**Re: Nusenda Credit Union at 6401 Uptown Blvd. NE
Erosion and Sediment Control Plan
Engineer's Stamp Date: 3/19/26 – H18E012 - (SWQ-2026-00013)**

Based on the information in your submittal received on 3/19/26, the ESC Plan can't be approved until the following comments are addressed.

ESC-2

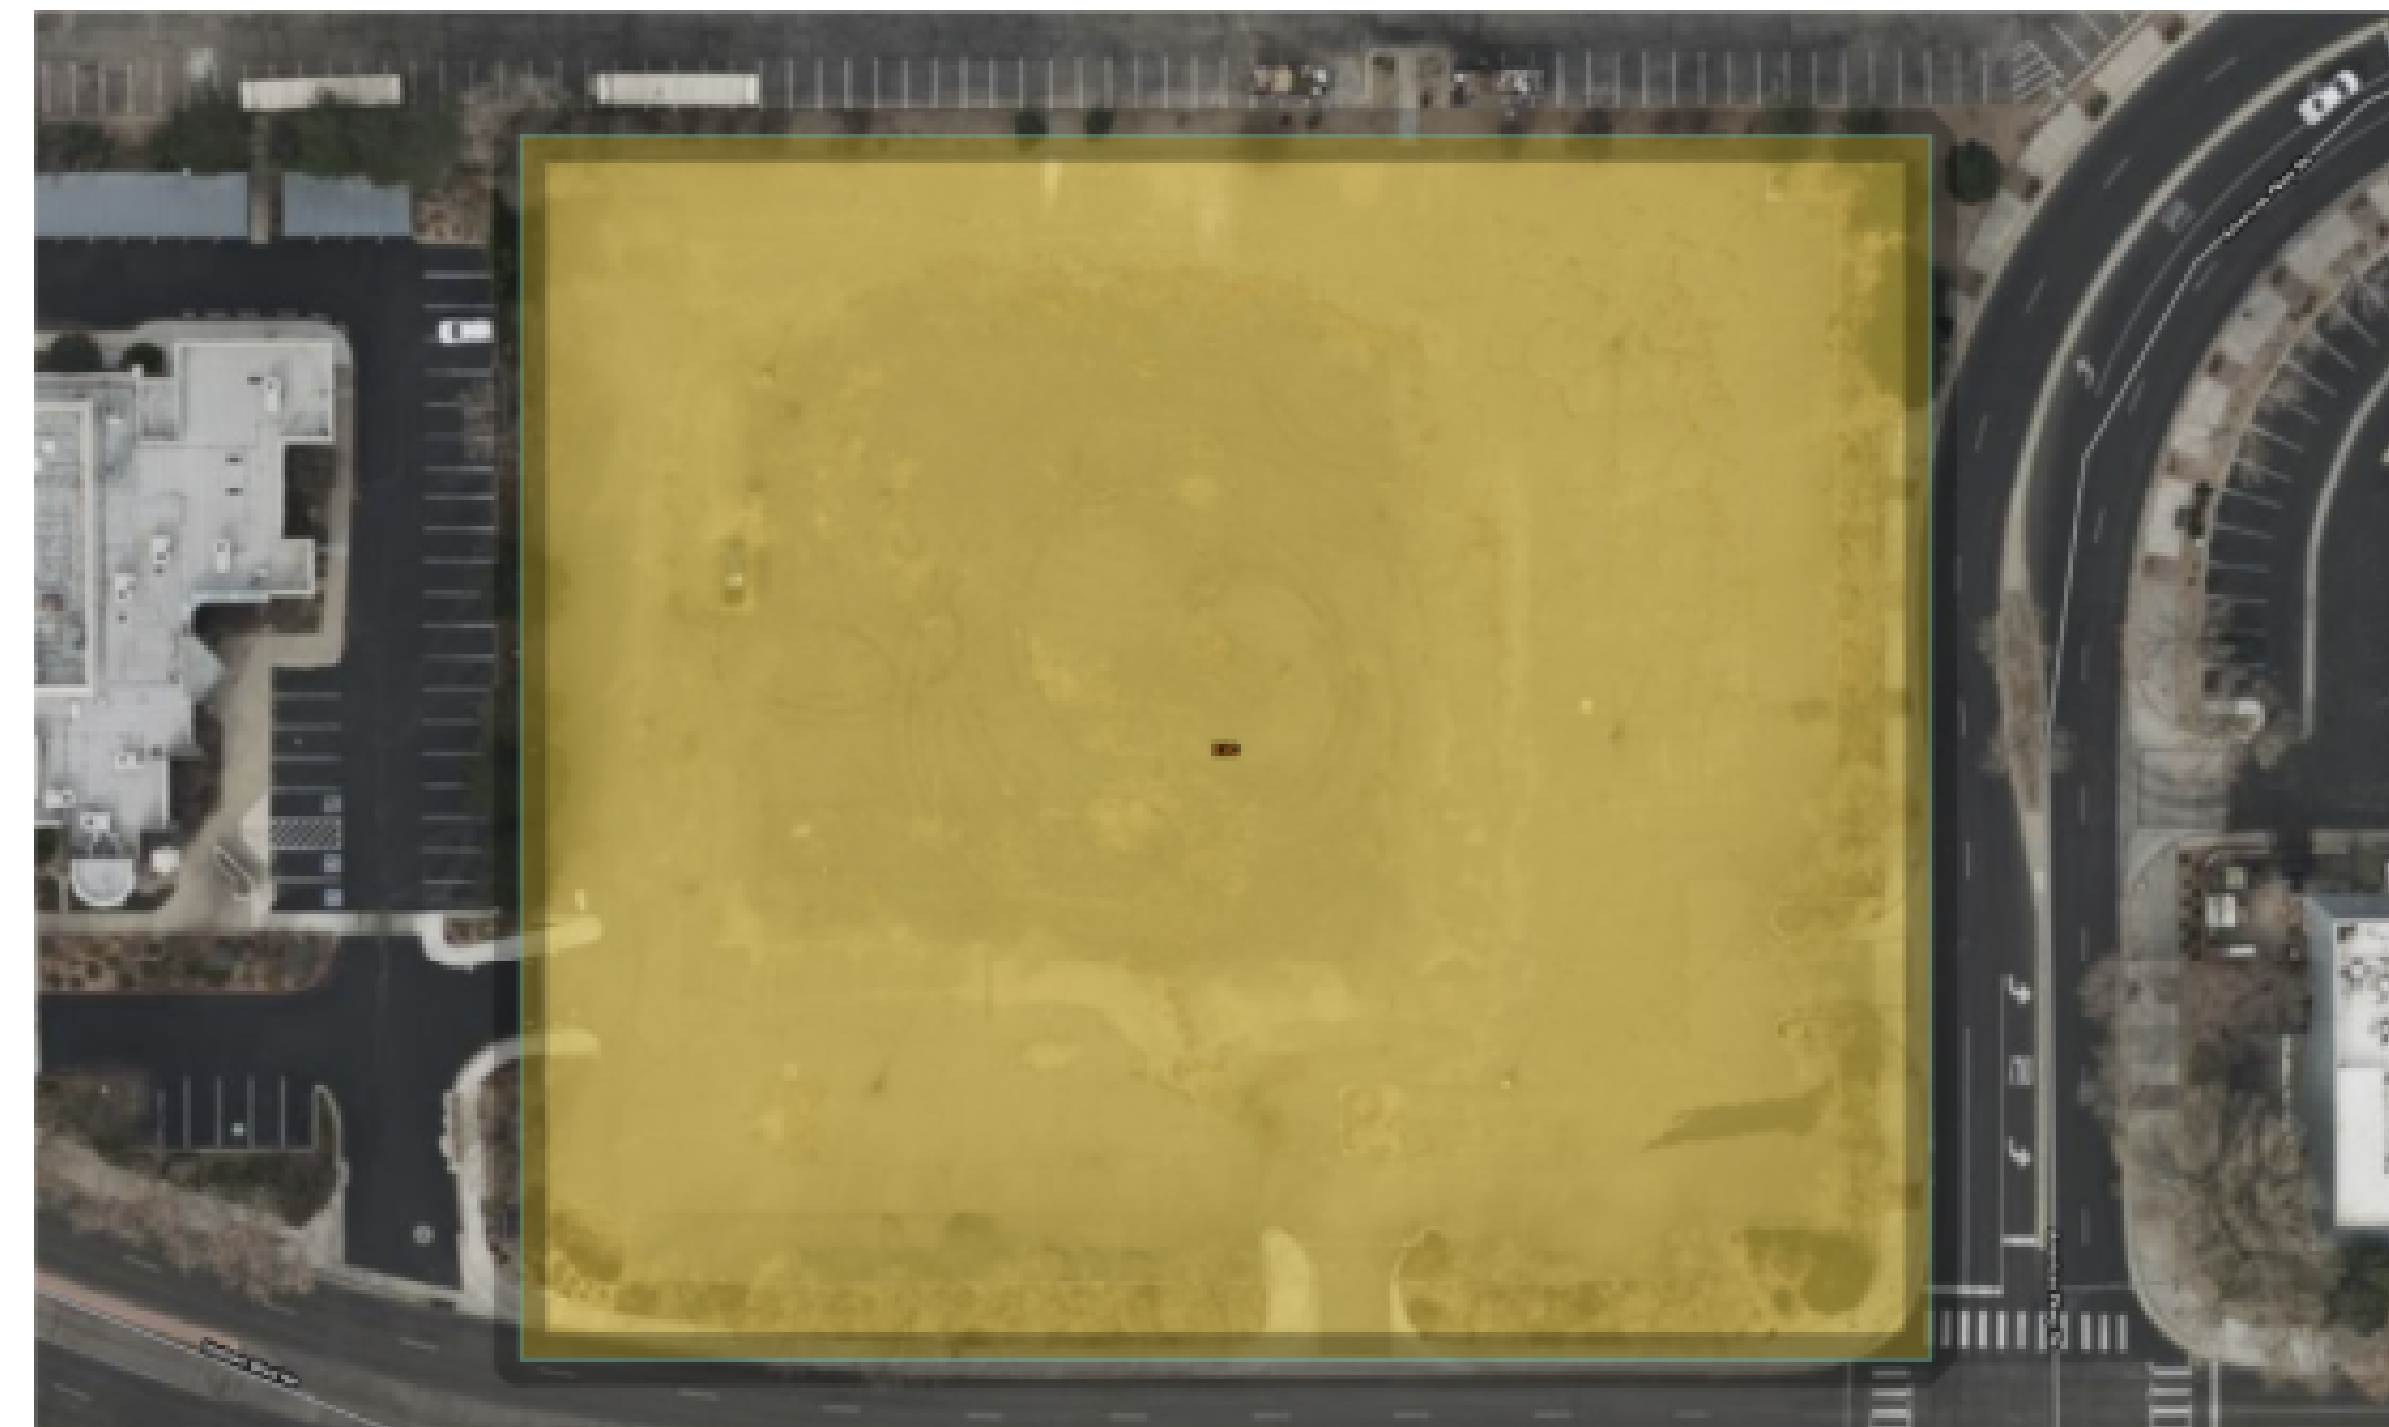
1. Please include a demolition plan for removing the existing parking lot, curbs, walls, and mature trees. Also, add demolition activities to the schedule on sheet ESC-2. Adjust the limits of disturbance to match the limits of demolition, especially along the downhill perimeter.

SEDIMENT BASIN & SEDIMENT TRAP (SB) & (ST)

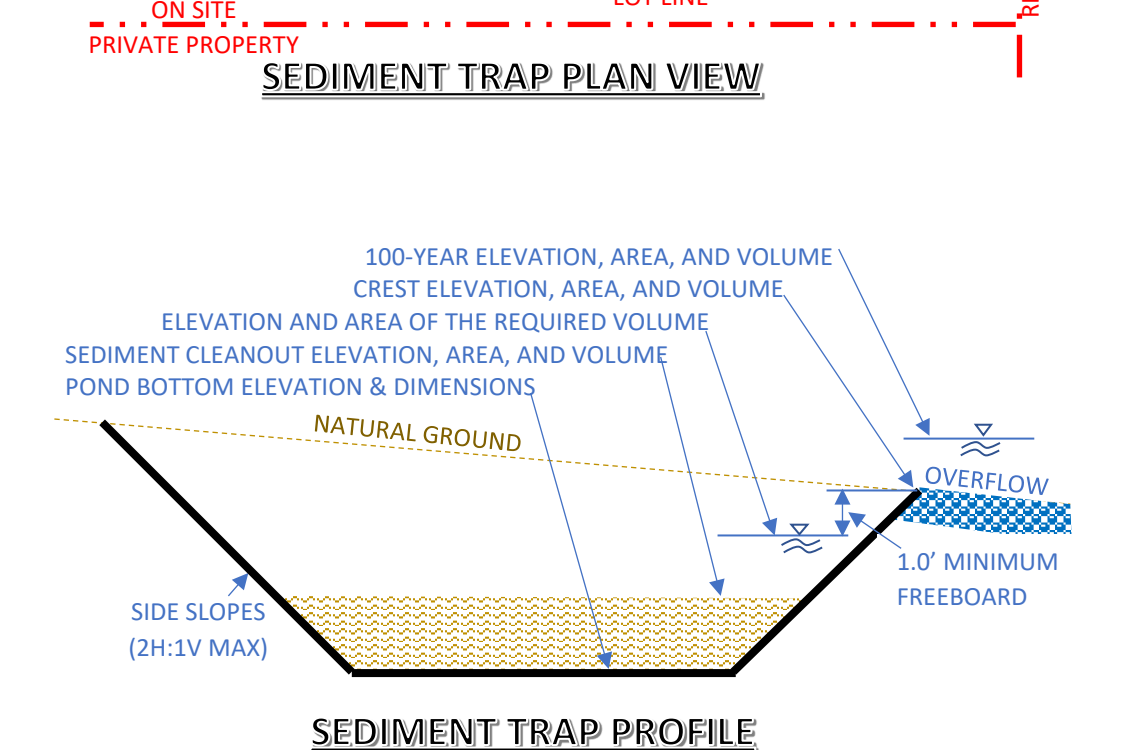
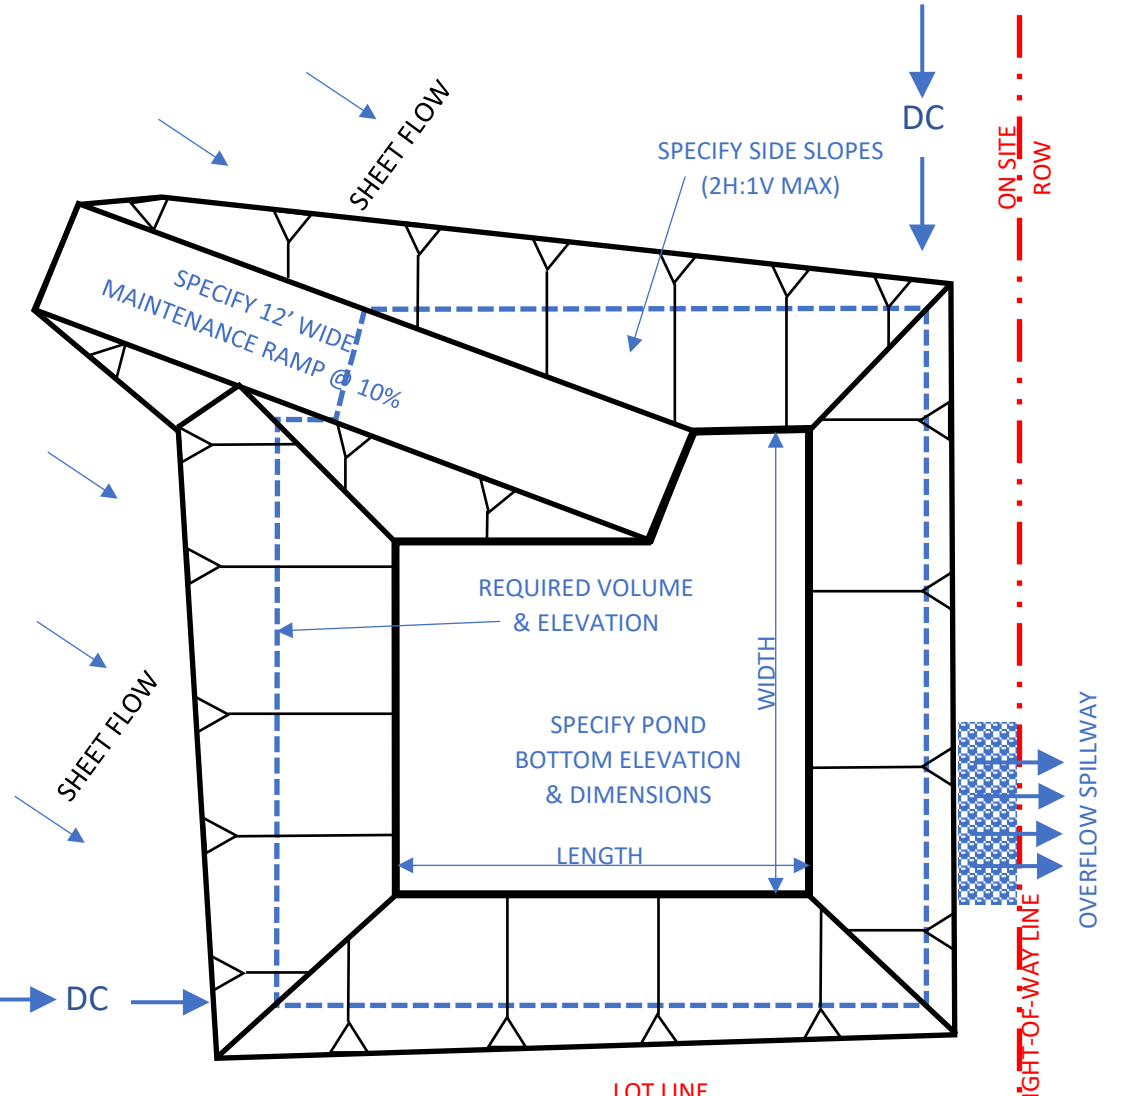
4. The specifications for the sediment trap geometry are missing and must include:
 - a. Elevation, dimensions, and area of the bottom.
 - b. Cleanout elevation, area, and volume.

- c. Elevation, area, and volume of the required volume.
 - d. Overflow crest elevation, area, and volume (must include 1 foot freeboard above the required volume).

- e. 100-year elevation, area, and volume (based on 100-year depth at spillway).
 - f. Spillway dimensions, materials, and location.
 - g. Basin side slopes.

- h. A table showing conic volume calculations.
 - i. A profile through the outlet, labeling these elevations.
5. Update the engineer's stamp date on all sheets each time a change is made on any sheet.
